Project 7179  
5 May 2026

**Attention: Lane Cove West Responsible Planning Group**

**12 MARS RD LANE COVE WEST – PROPOSED DATA CENTRE**  
**NOISE EMISSION ASSESSMENT – EXPERT PEER REVIEW**

DRAWING NUMBER
MAR-AR-DRG-21004

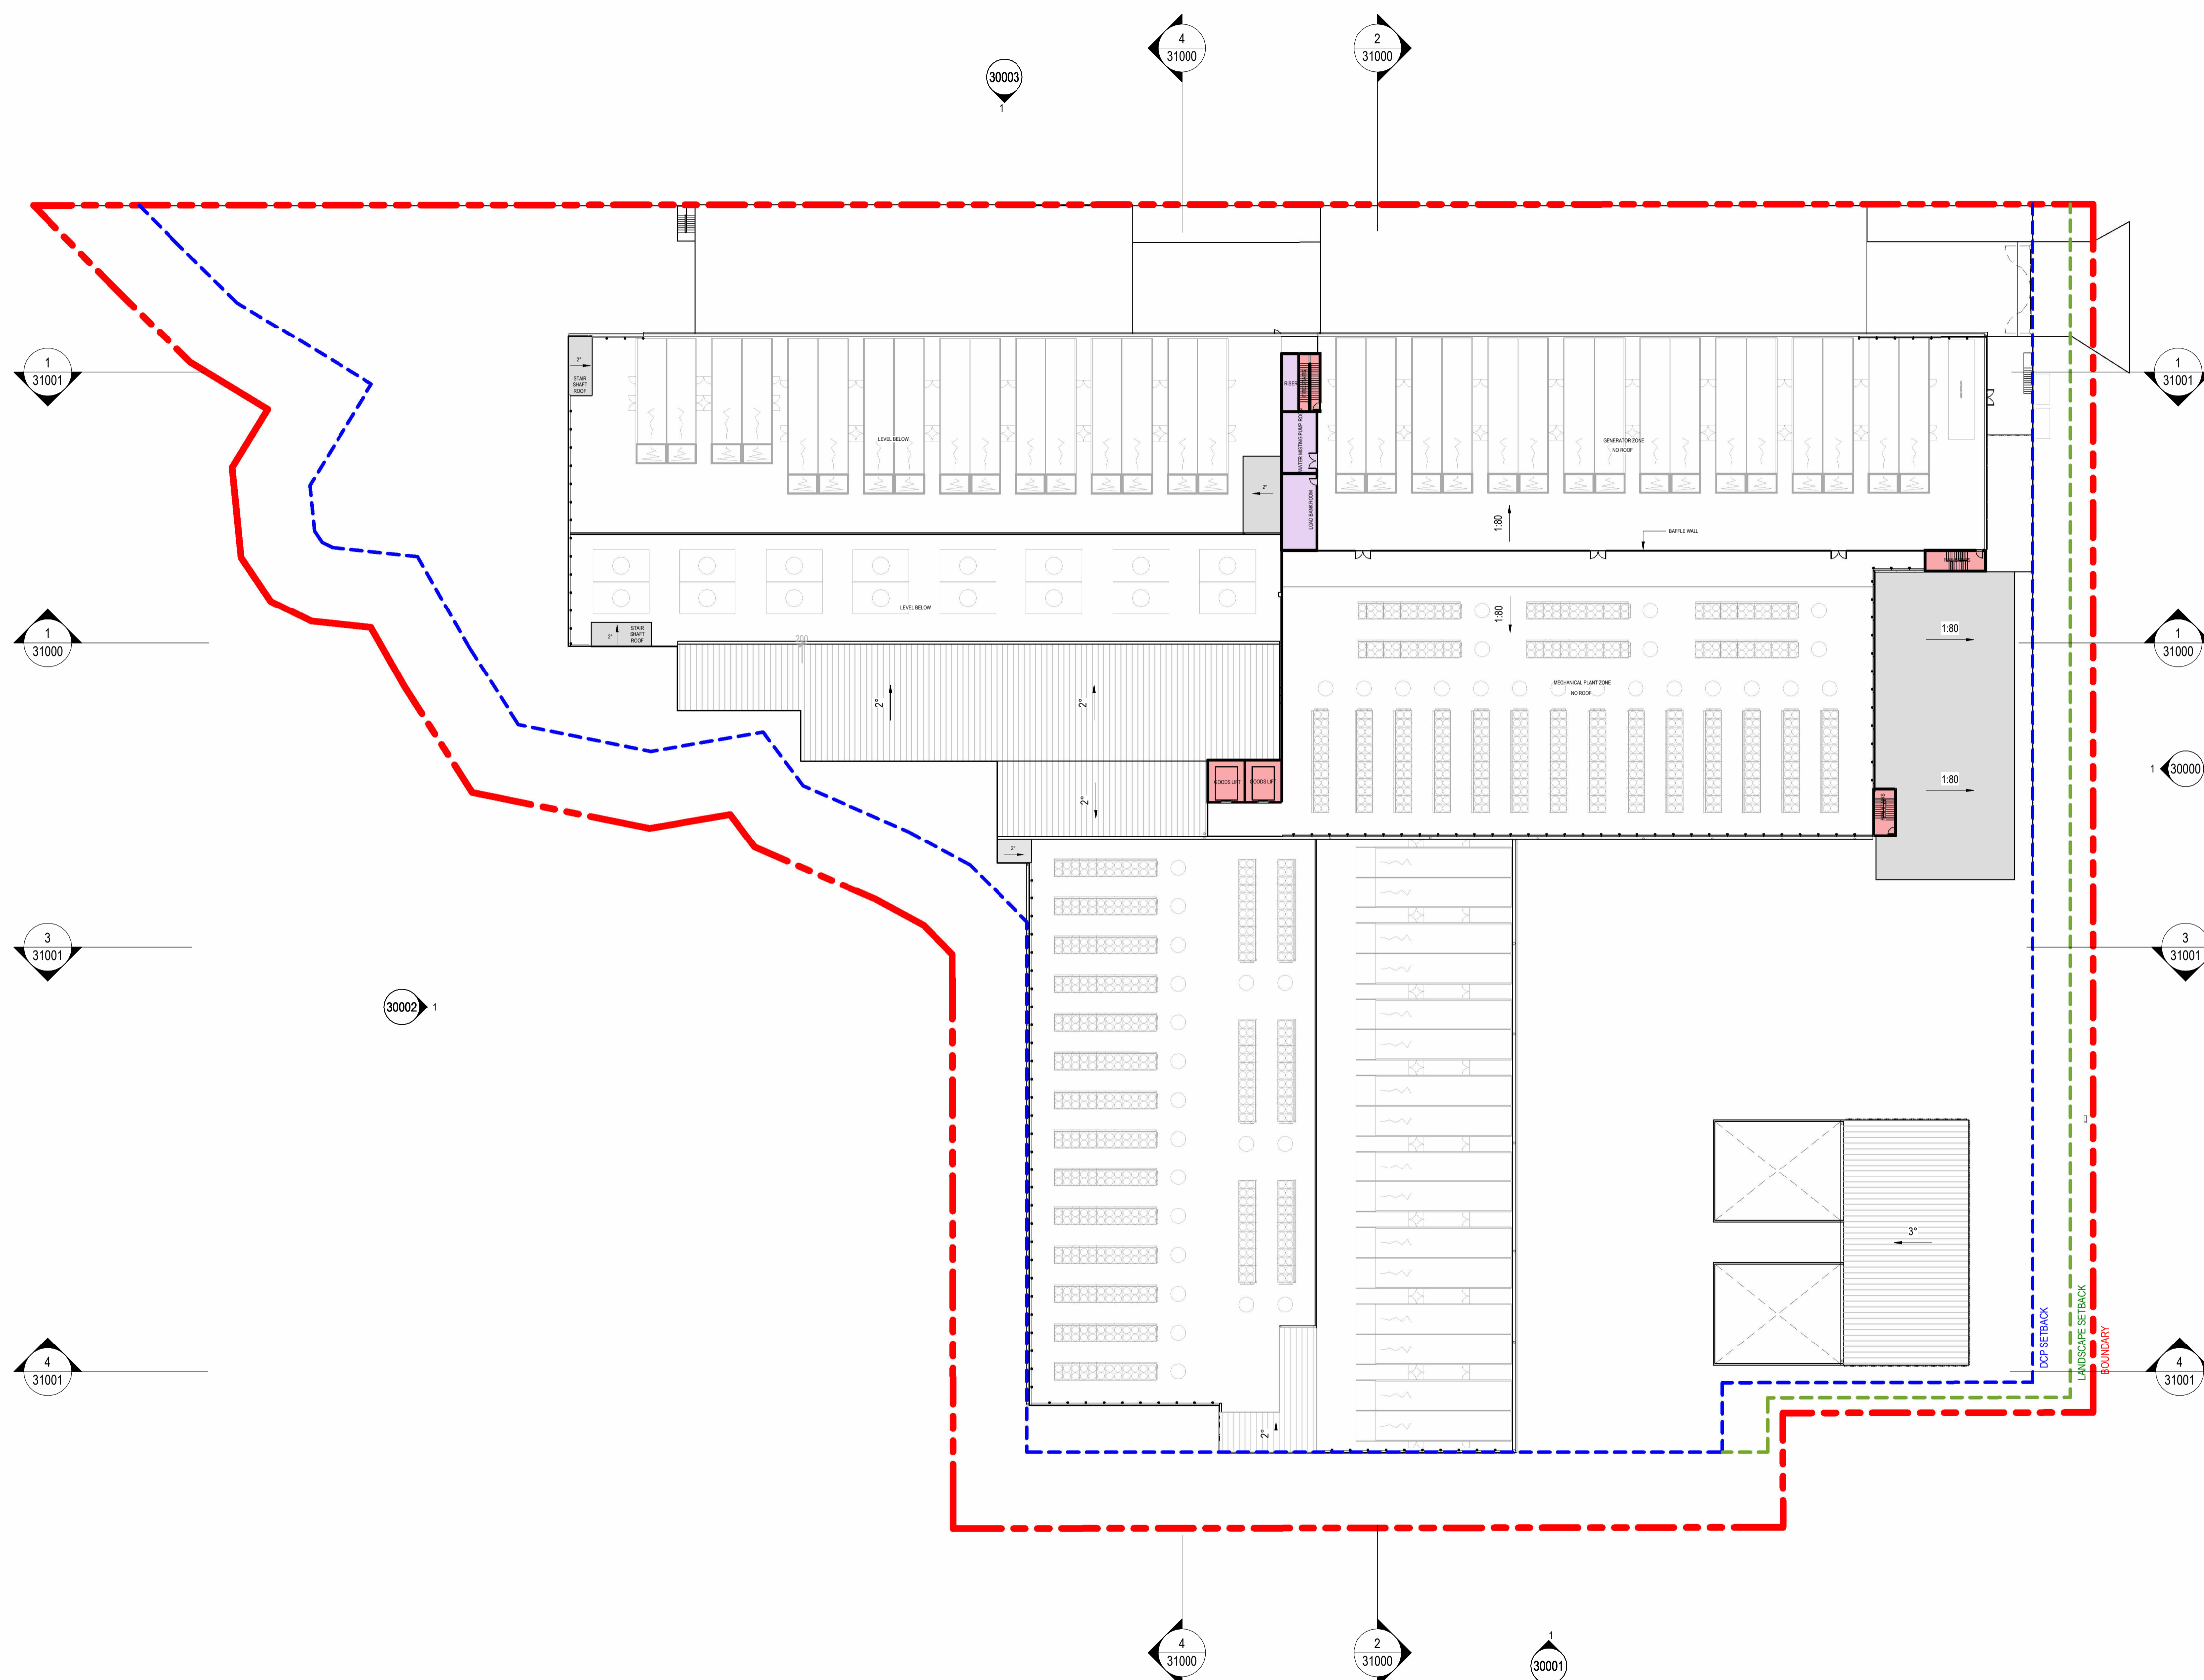
35. Within *Table 23 Mechanical Plant*, SLR discuss the SWLs for the proposed backup generators. Design SWLs are presented for the air intake, discharge and exhaust stack. Presumably, these generators and their enclosures are yet to be designed and constructed, as they are, in Acoustic Dynamics' experience, bespoke to the requirements of any given site.
36. Acoustic Dynamics advises that consideration of breakout noise through the enclosure itself should also be considered, as a "shipping container style" enclosure is likely to be insufficient to adequately mitigate breakout noise from the operation of the generator.
37. Significant care must be taken during the design of the emergency generators, to ensure the noise emission of the assembled generators and enclosures matches the predictions of SLR;
38. Within *Section 4.2.1.4 Mechanical Plant*, SLR states:
